TO	Anthony Murr (Director, Project Strategy)
FROM	William Xie (Transport Engineer, Ason Group)
CC	James Laidler (Principal Transport Engineer, Ason Group) Masoud Khodadadifard (Transport Engineer, Ason Group)
SUBJECT	Access Logistics Park, 884-928 Mamre Road, Kemps Creek – SSD 17647189 – MOD 3

Ason Group has been commissions by Project Strategy to prepare a Technical Note (TN) to review the traffic and transport implications of the proposed Modification 3 (MOD 3) to the approved Access Logistics Park (SSD-17647189) at 884-928 Mamre Road, Kemps Creek (the Site).

- Closure of the connection of the access road which intersects with Mamre Road directly south of Lot 2. This was previously proposed to be under a left in left out (LILO) arrangement. To replace this LILO arrangement, there is a light vehicle turning head proposed at the end of the access road.
- Access for the Site as a result would be through the internal road network of the Site directly north, known as the Aspect Industrial Estate. This site offers an internal road connection up to Mamre Road, known as the Mamre Road / Mirvac Access intersection (proposed under SSD-10448¹).
- Minor change to the proposed road widening

Drawing Title:
**Stage 2 Estate Master Plan /
Benching Plan**

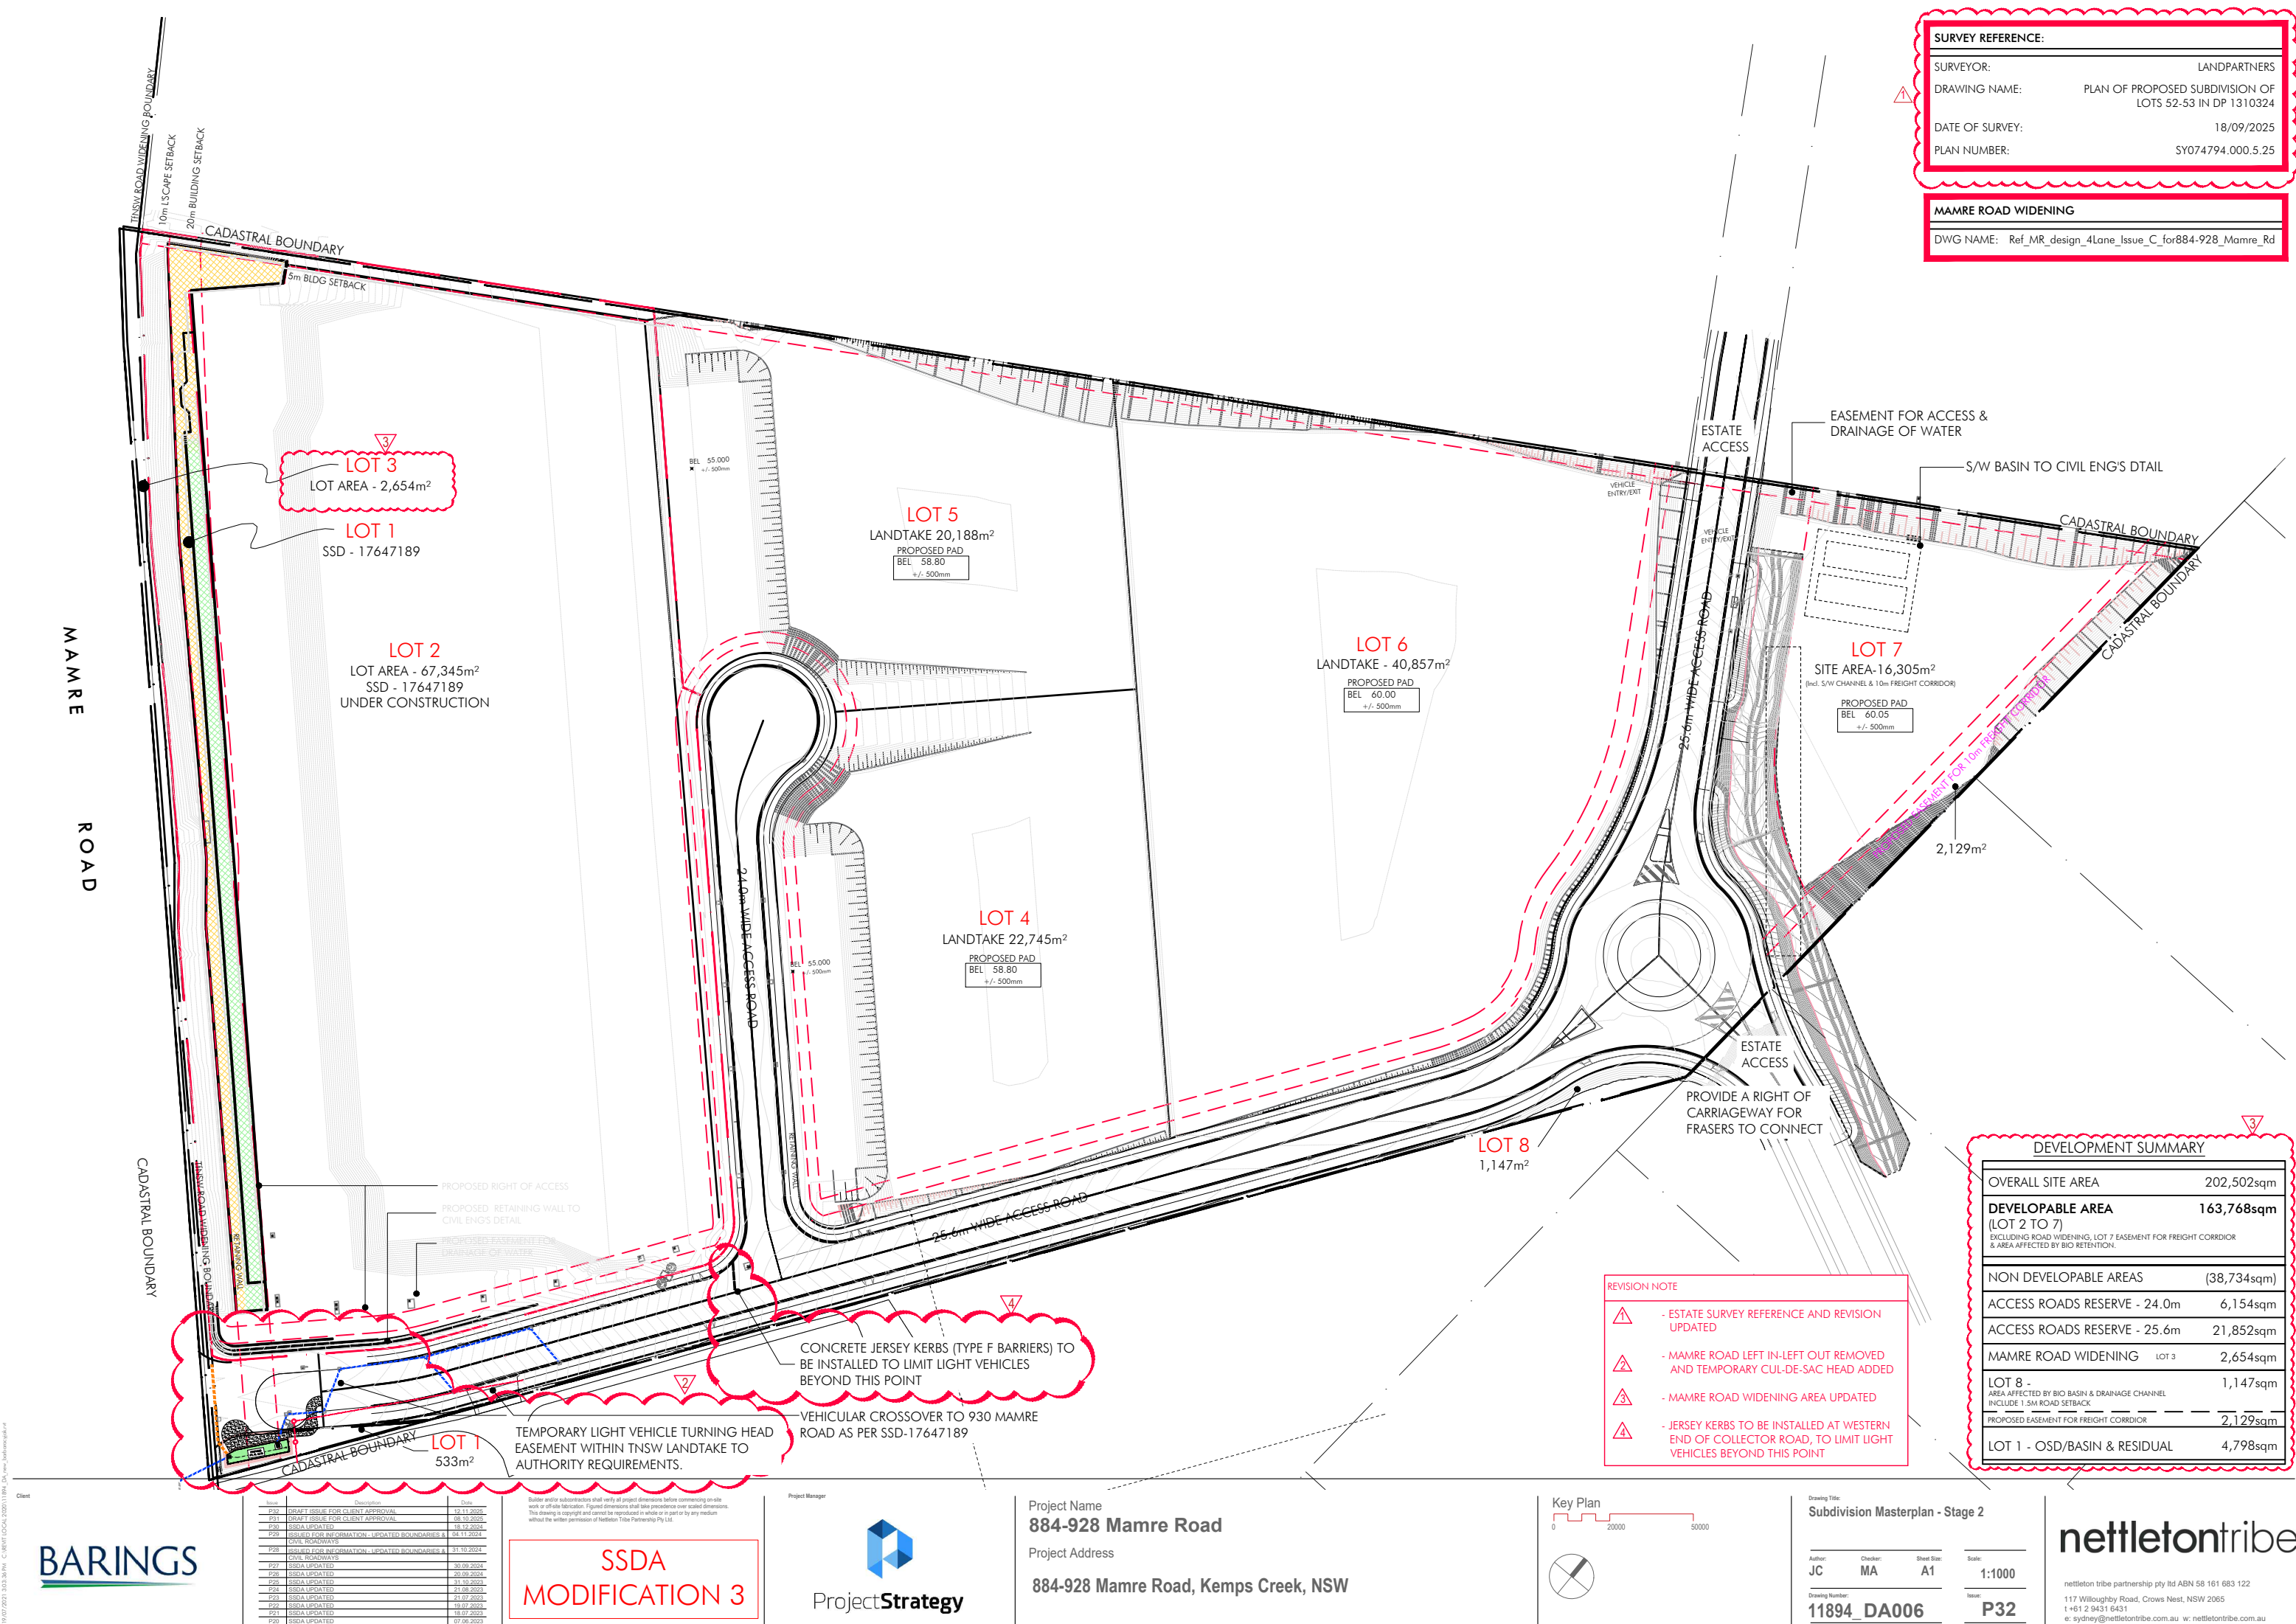
TABLE 2: RESPONSE TO DPHI COMMENTS		
	Comment	Ason Group Response
1	The Traffic Statement states that the LILO intersection is an interim arrangement, however this isn't consistent with the original DA or the DCP road network plan and doesn't reflect the intention of this modification that TfNSW will deliver this intersection as part of the Mamre Road upgrades. Please update the Statement as necessary.	This document has updated the description of the LILO. Additionally, this MOD 3 submission, in part, seeks to amend the original approval by removing condition to provide the LILO. Vehicles would be directed to utilise the signalised intersection at Darrabarra Ave via Berriwerri Dr to access to/from the Site.
2	The Statement is also unclear on how the modification is consistent with the modelling done as part revised Transport Management Accessibility Plan (TMAP) submitted as part of the original DA – particularly in relation to the Aspect signalised intersection on Mamre Road. The TMAP modelling for the performance of the Aspect intersection appears to have been on the basis that the LILO was also delivered and operational. The Statement should be clear on how it has considered 100% of the traffic of the development accessing the site via the Aspect intersection.	A previous assessment has been undertaken which deferred the construction of the LILO – refer to Attachment 1 – which demonstrates that the intersection of Mamre Rd x Darrabarra Ave can sufficiently accommodate the additional traffic.

With this MOD 3 proposal, the LILO arrangement would be removed and coincide with the operation of the Mamre Road / Mirvac Access signalised intersection. A turning head accommodating light vehicles is proposed at the end of the access road to turn around as necessary.
